MONUMENT FIRE DISTRICT
16055 Old Forest Point, Suite #102
Monument, CO 80132
(719) 484-0911
www.monumentfire.org
Proudly serving the Tri-Lakes Region

To: Development Review, El Paso County
From: Jonathan Bradley, Fire Marshal
Subject: Urban Landing PUDSP
Date: July 31, 2024

The Monument Fire District has reviewed the PUD development plan for Urban Landing. Based on our initial review of site access, water supply, and fire mitigation, we have the following comments.

URBAN LANDING
PUD DEV. PLAN & PRELIMINARY PLAN
SITE PLAN SHEET

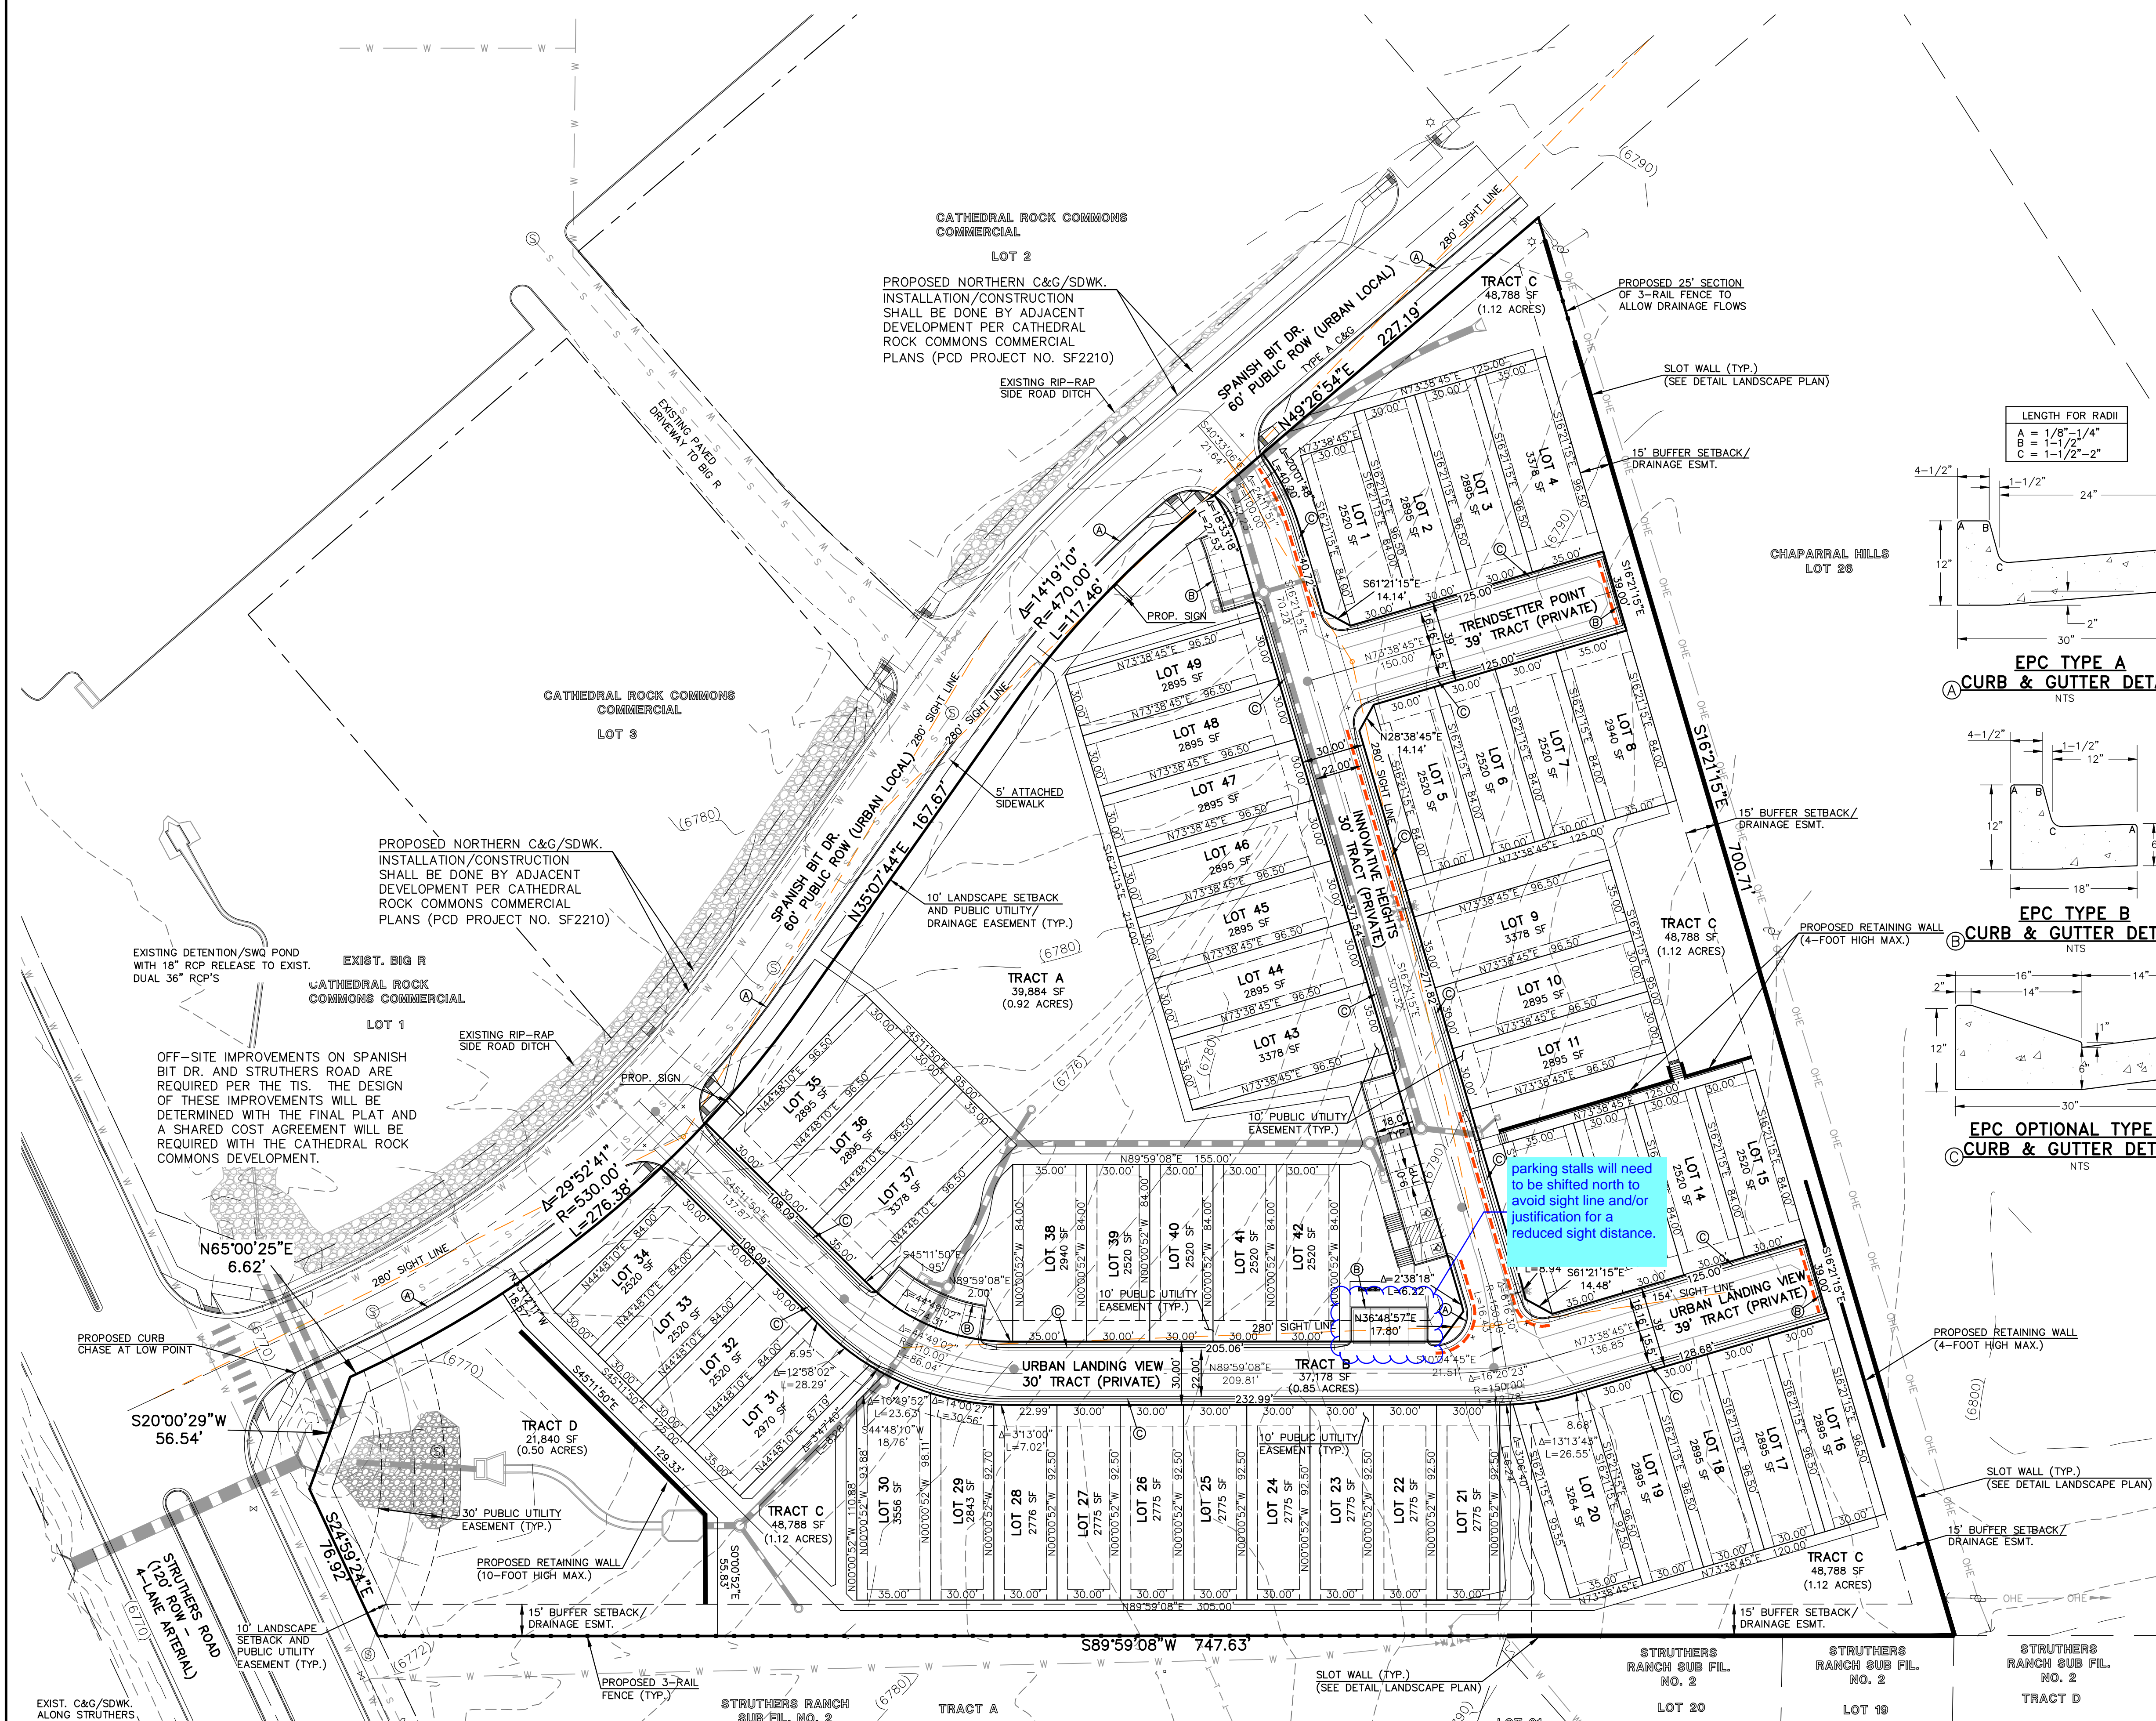
- FD prefers EPC Optional Type C curb and Gutter throughout the development (except designated parking areas) due to narrow roadways to allow large fire apparatus to mount the curb while turning or passing without damaging wheels and tires (see page 3 of 9 in PUD Development Plan).
- Evaluate turning radius for attached fire apparatus drawing and determine if proposed roadways will accommodate large vehicle operation.

"USE" EASEMENT & "MAINTENANCE" ACCESS EXHIBIT

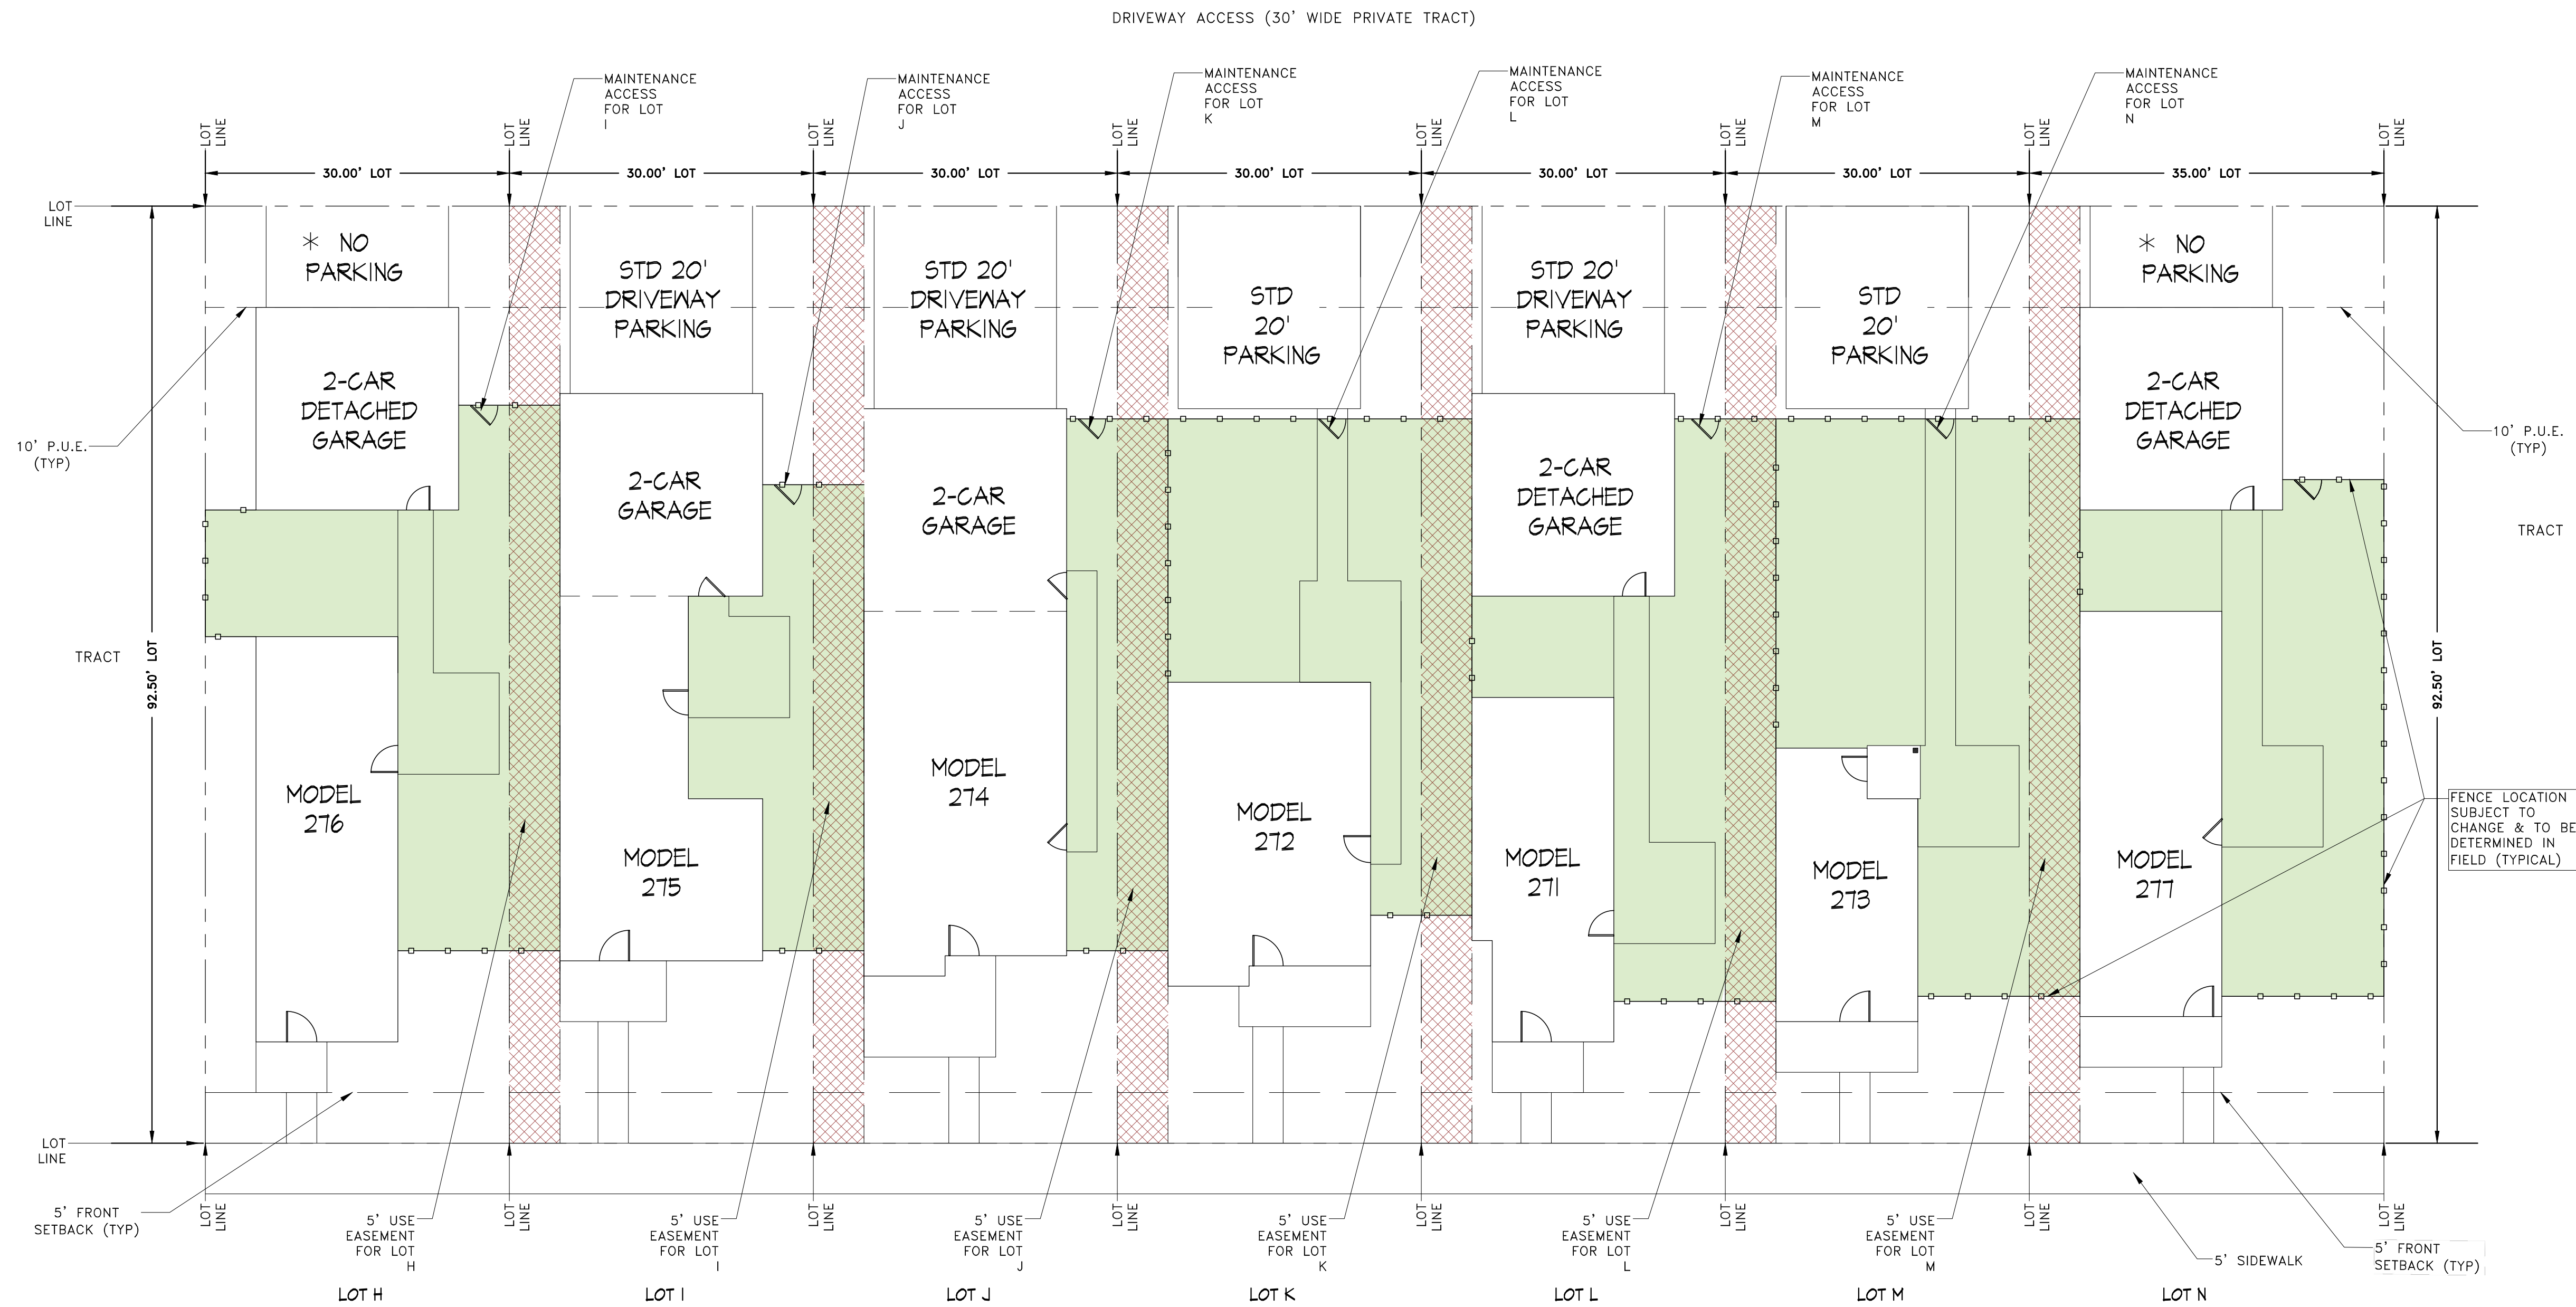
- Are road widths mostly 22' (except Trendsetter Pt and Urban Landing View extension)?
- Does the 5' use easement between every lot in this development provide open access from the the street side to the rear of each house?
